211813 CFAA

## Modification 7 Precinct Village and Carpark (SSD-9835-Mod-7)

### Technical Note on Flooding in Response to DPE Comments

Legend

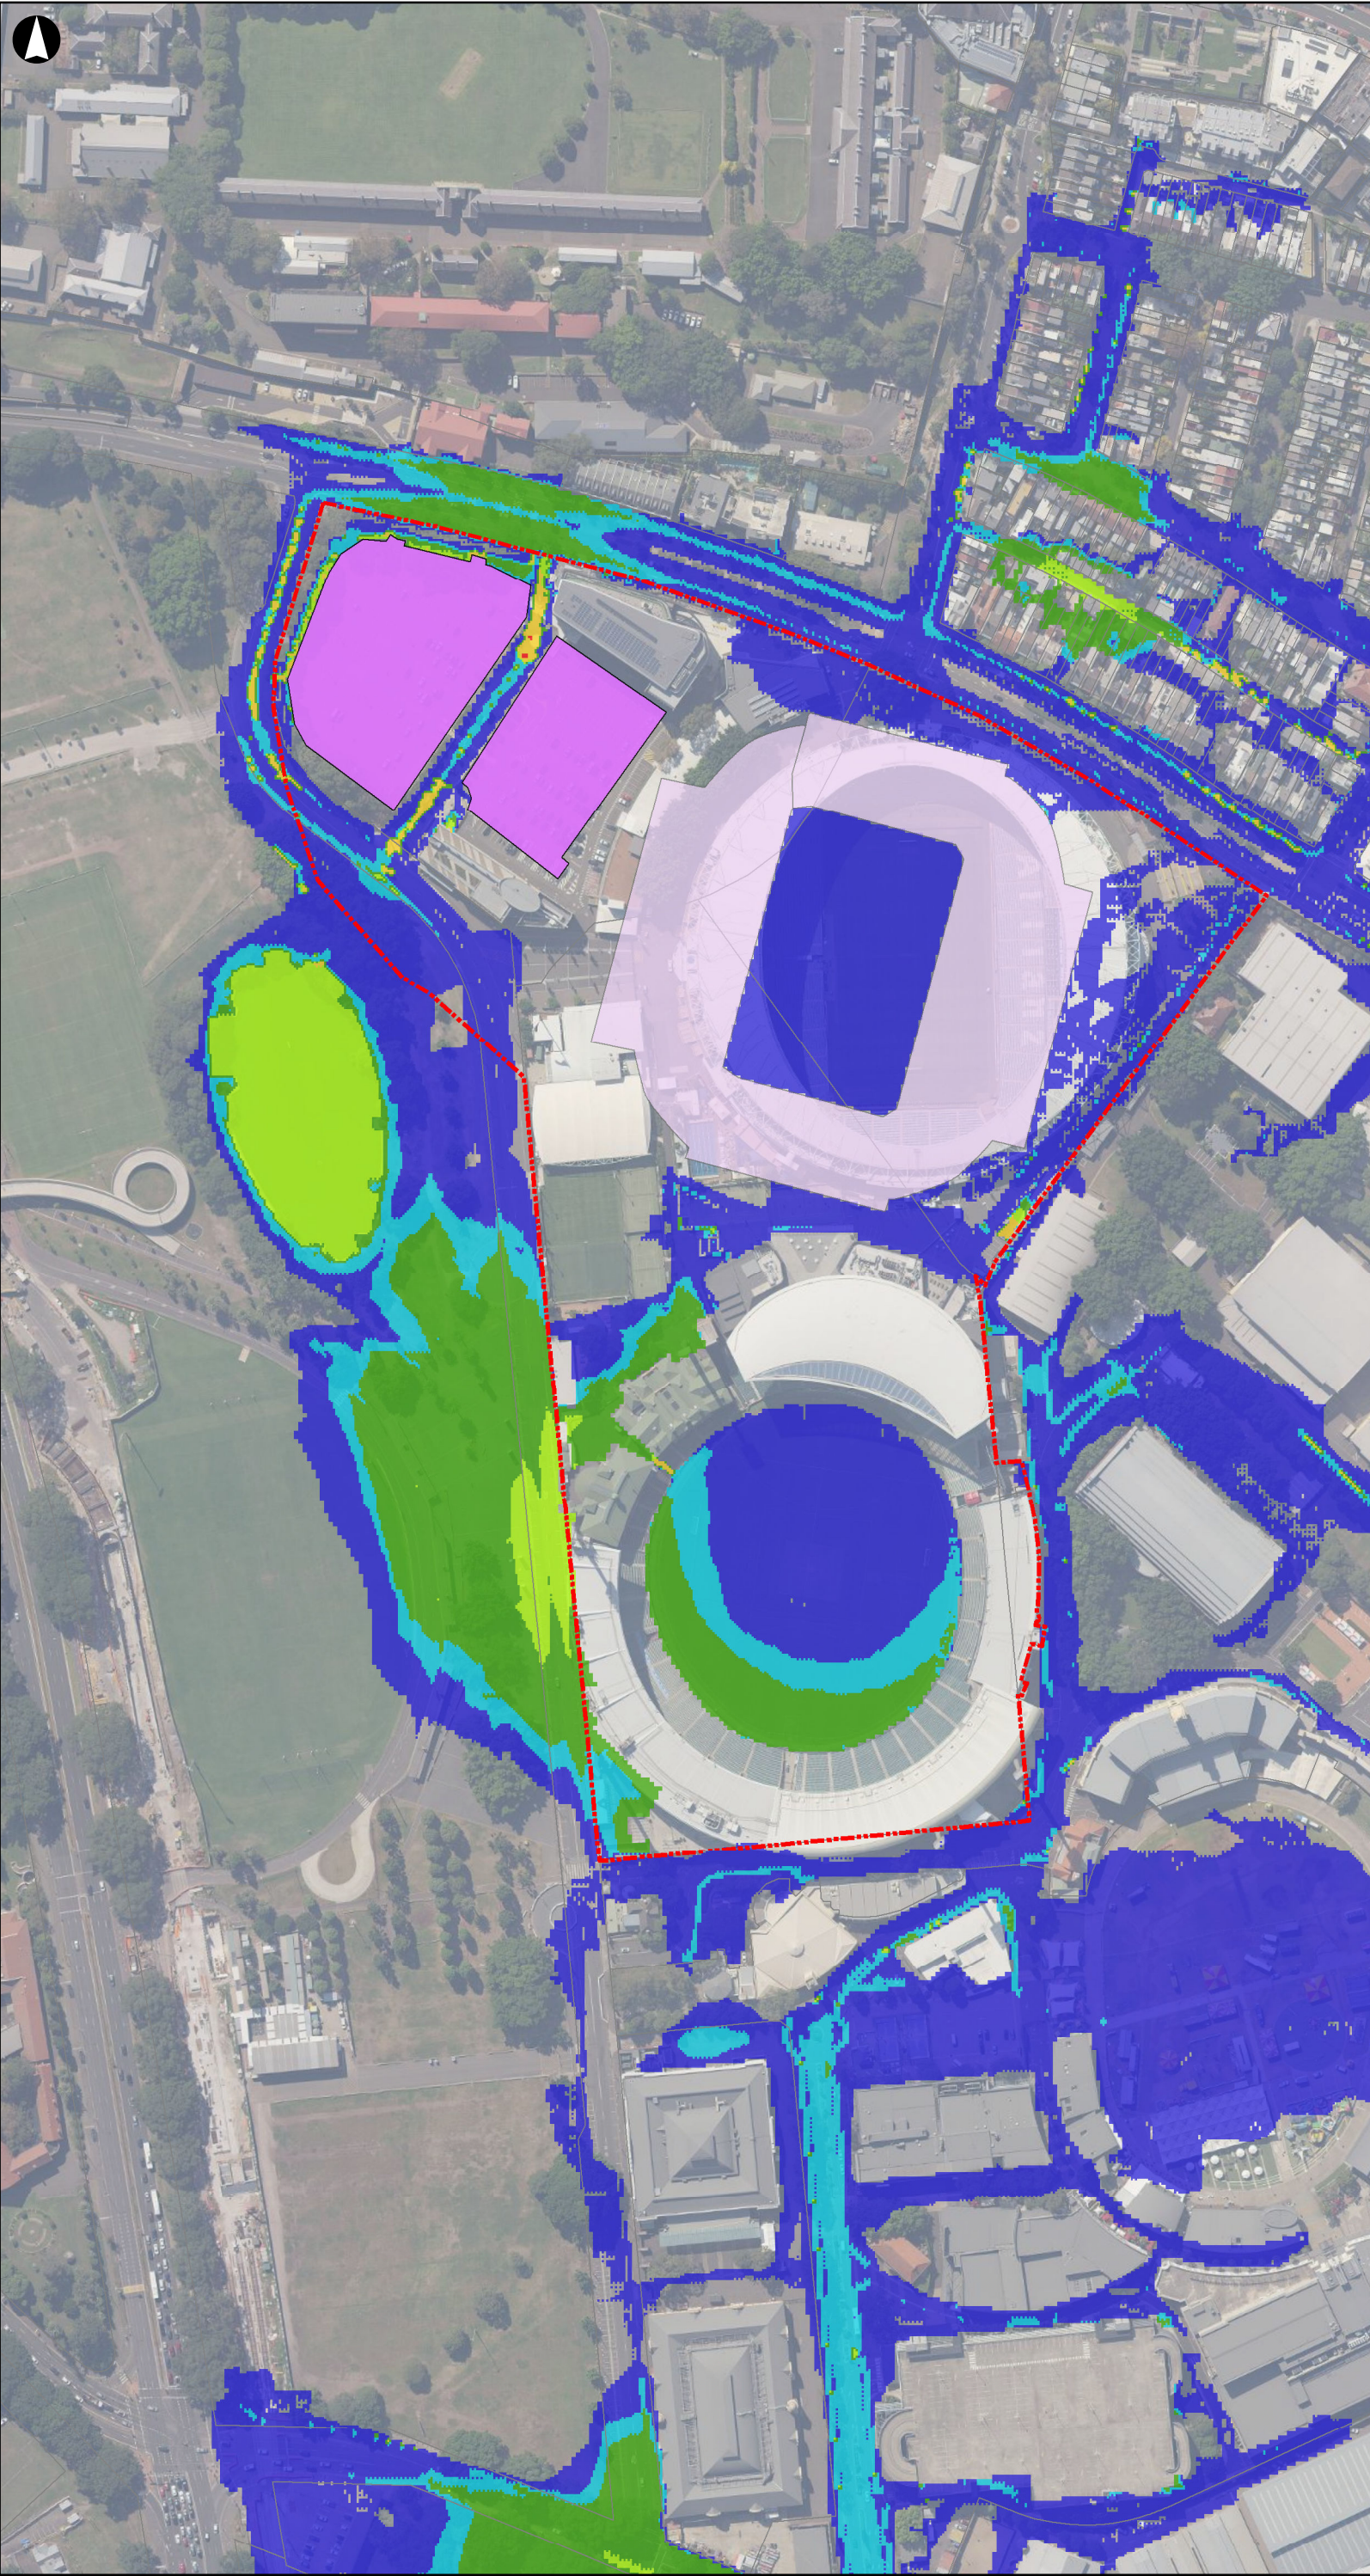
- there are only three figures presented in Appendix G, presumably showing hazard. The RtS states afflux figures were provided, but they are not available at Appendix G. Figures as per the original report should be updated, including depth/level and afflux

Additional figures have been included in section 4.0 that show flood levels, depths, hazard and afflux associated with the proposed development.
